14 August 2018

File No: R/2015/8/D
Our Ref: 2019/406219

Response to Submissions – Crown Sydney Hotel Resort, Barangaroo South – SSD 6957 MOD 1

Drawing and CAD File Number:
00915 - P - 0103 - TP

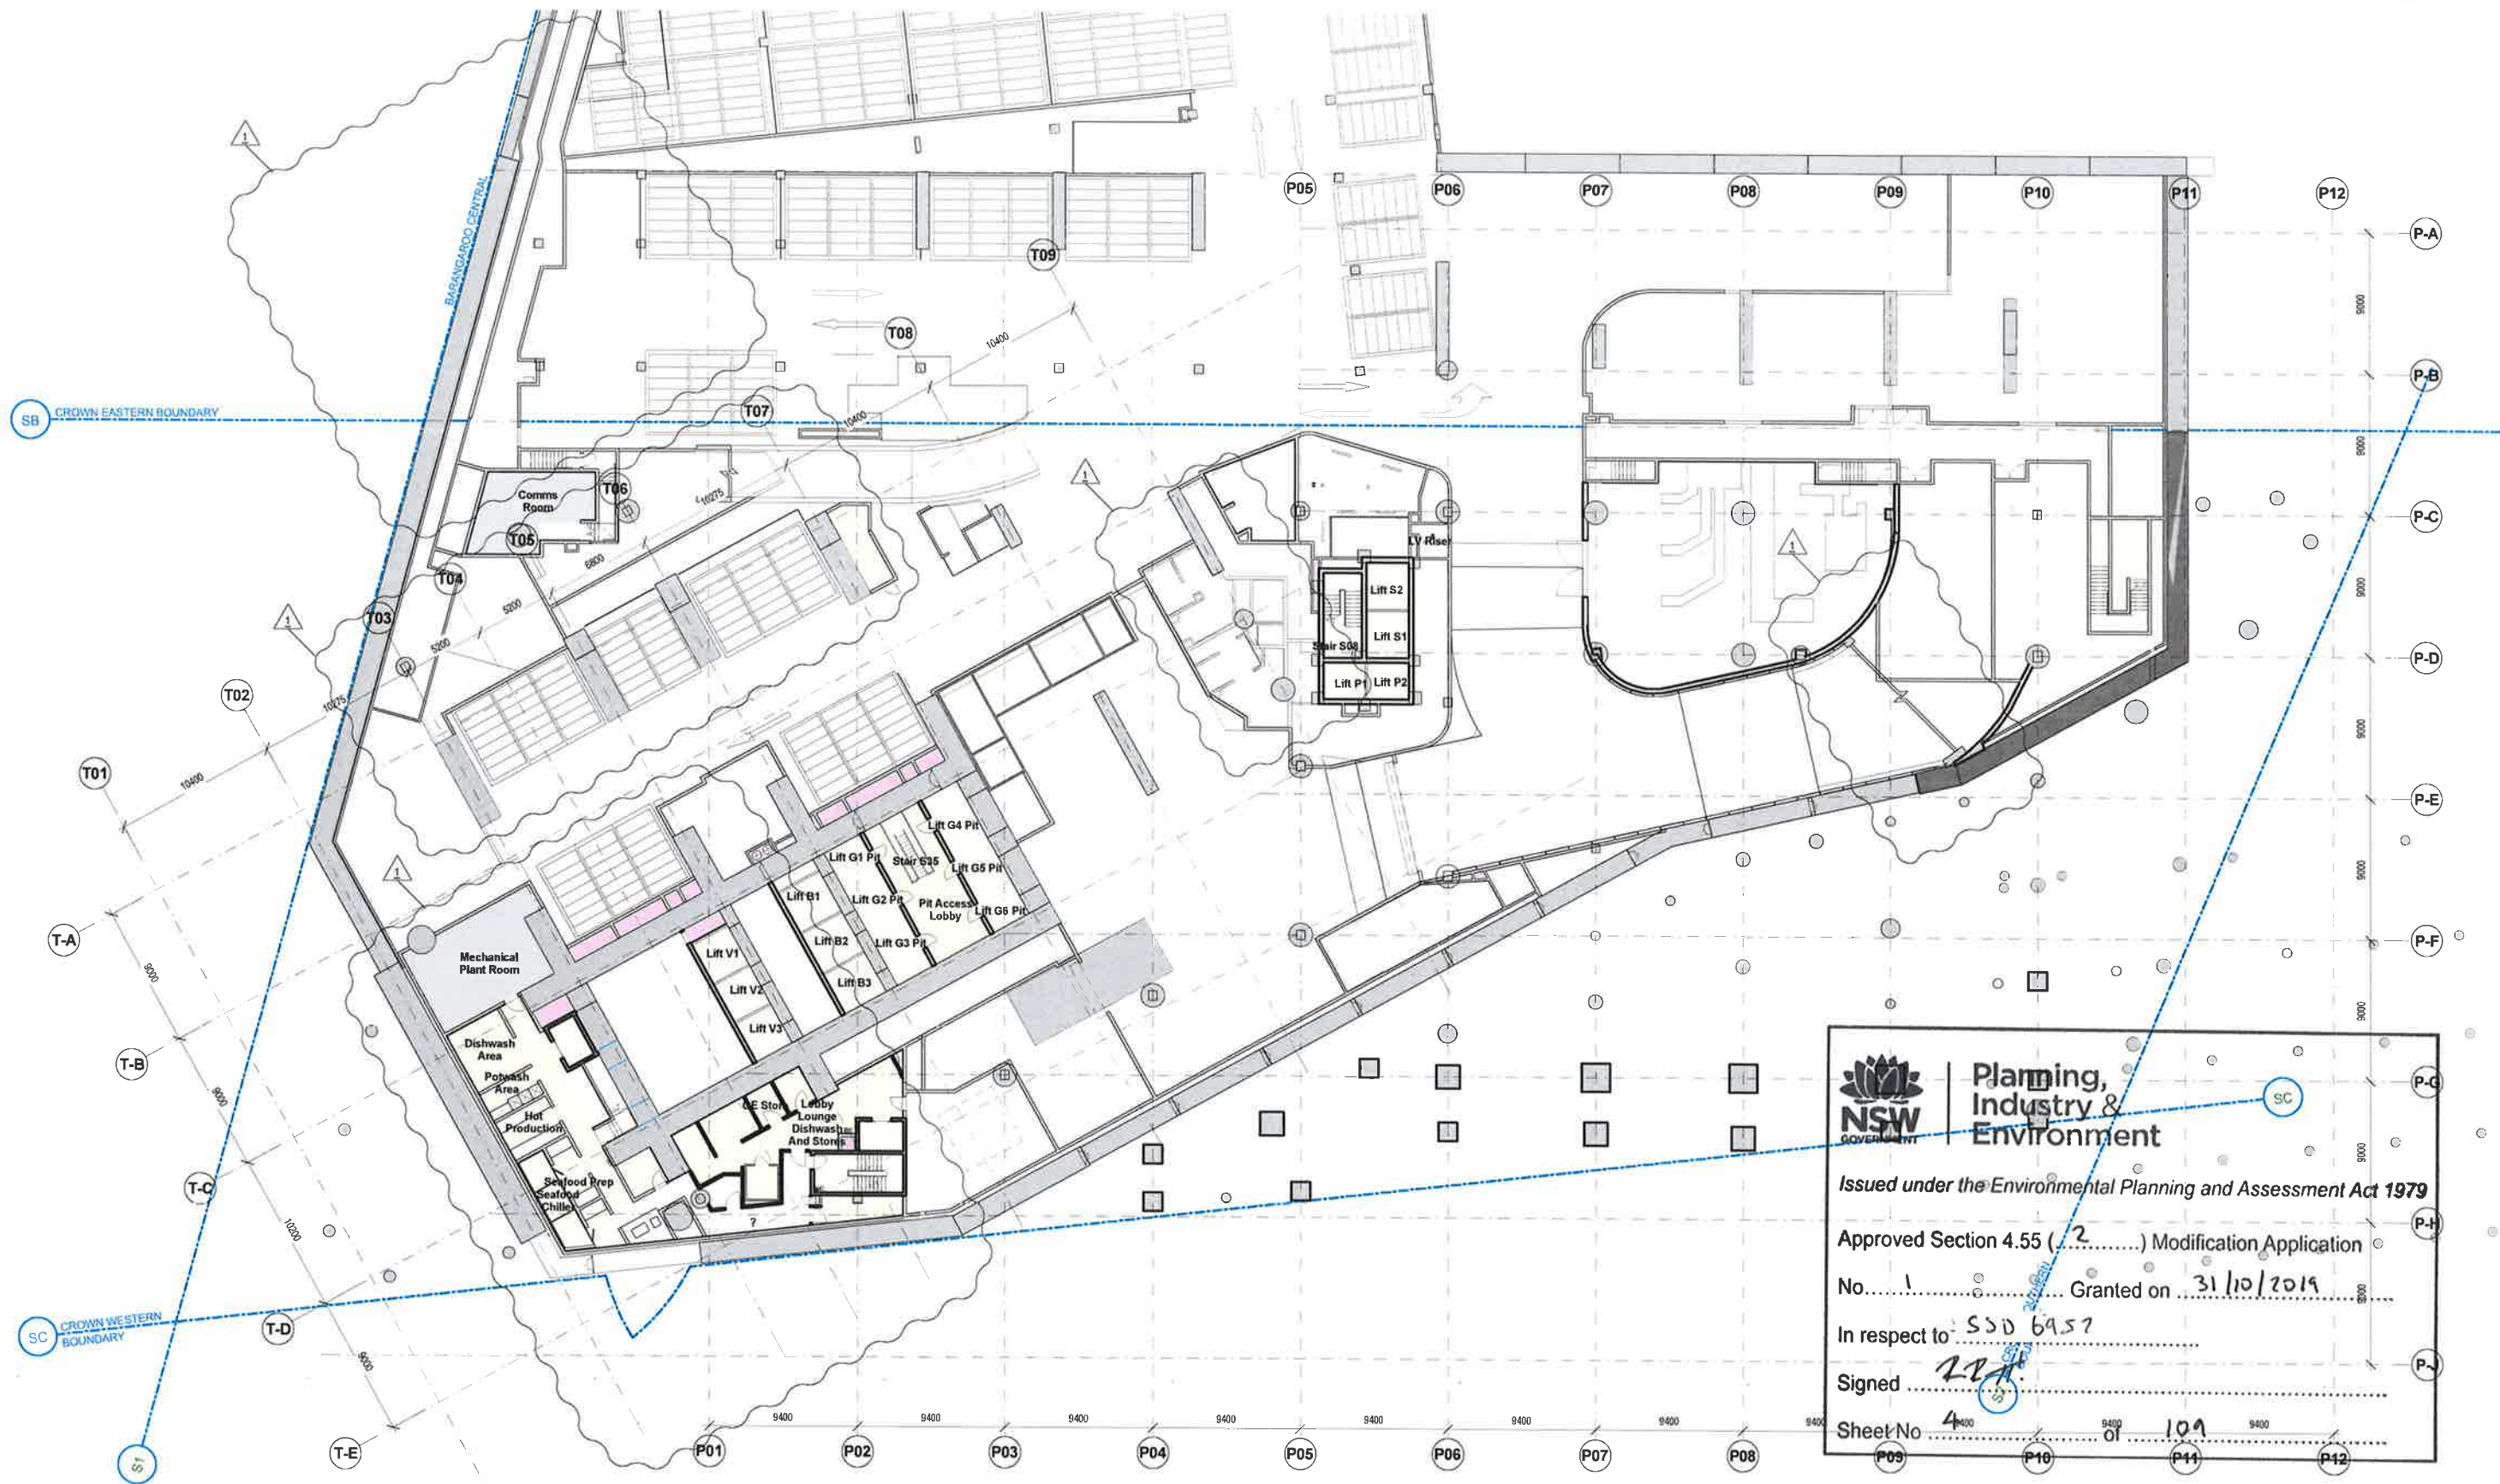
The applicant's RtS notes wind blades surrounding the outdoor bar terrace are glazed and are only 1.8m in height. There is a discrepancy on the submitted plans, however, that is yet to be addressed. The City's previous correspondence provides an excerpt from the submitted section drawing showing wind blades to be 3.4m in height and not 1.8m as suggested in written documentation. This is to be amended prior to the determination of the application.

The City also recommends that a condition be imposed that restricts the height of the blades to 1.8m and requires blades to remain staggered and not form a continuous glazed wall. Further, a condition is recommended to be imposed that ensures blade panels remain 100% transparent at all times and are not obstructed by any coverings (i.e. signage).
